Town & Country Planning Act 1990 (as amended)
Town & Country Planning (Development Management Procedure) (England) Order 2015

Application for Planning Permission for Works or Extension to a Dwelling

Development: Erection of single storey rear extension following the demolition of existing rear lean-to.
Location: 5 Highland Avenue Bognor Regis PO21 2BJ

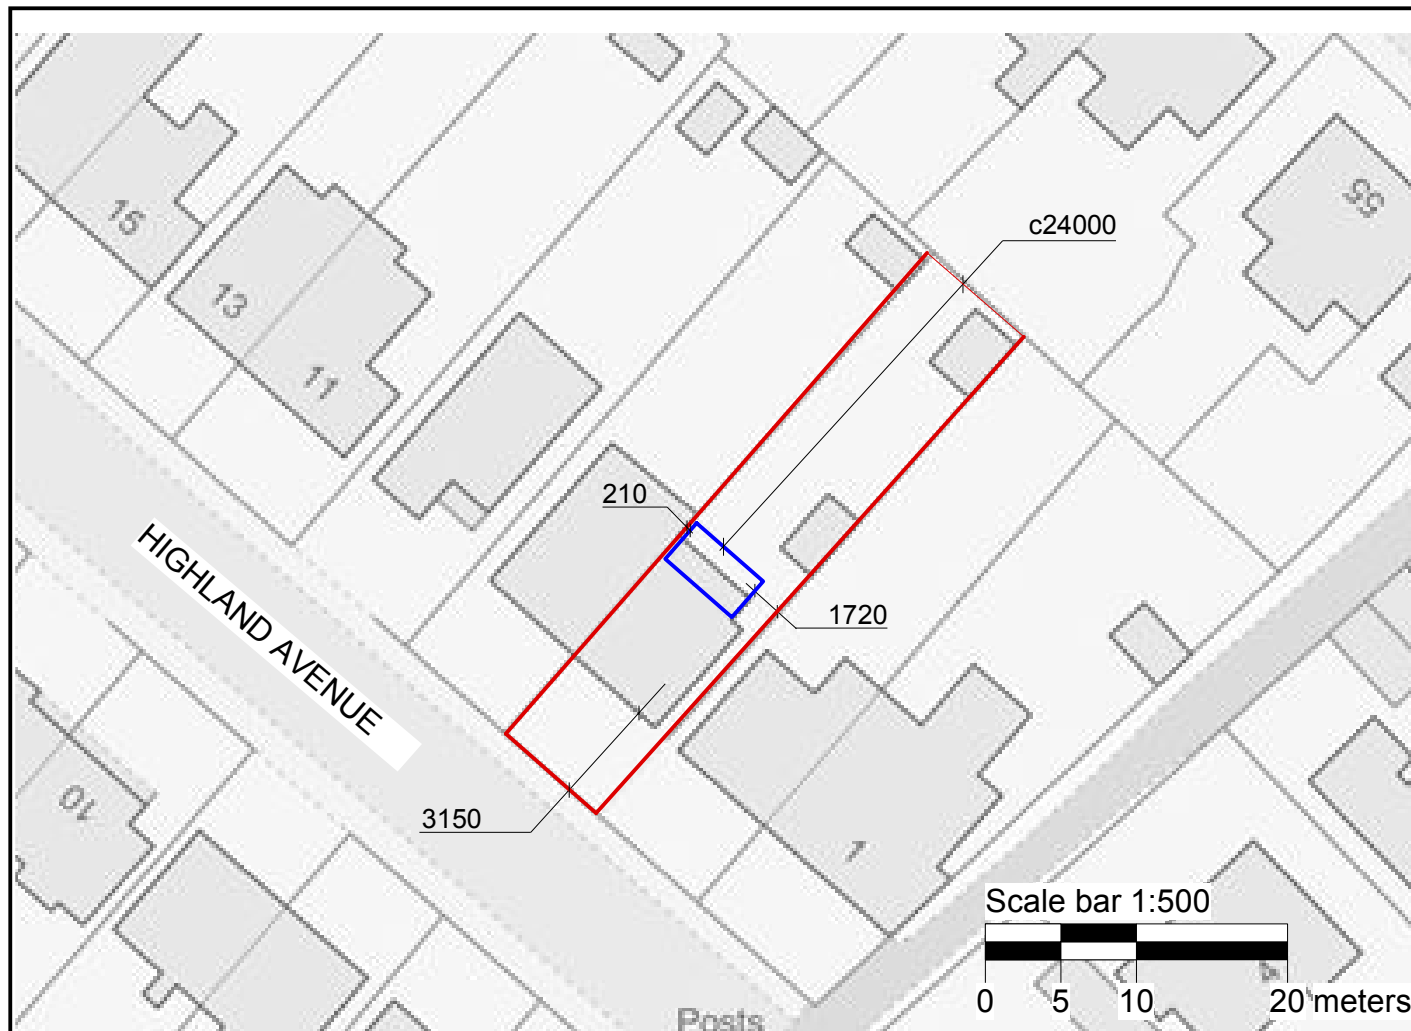
Block Plan

You are required to have dimensions from the proposed extension(s) to all site boundaries. Please amend.
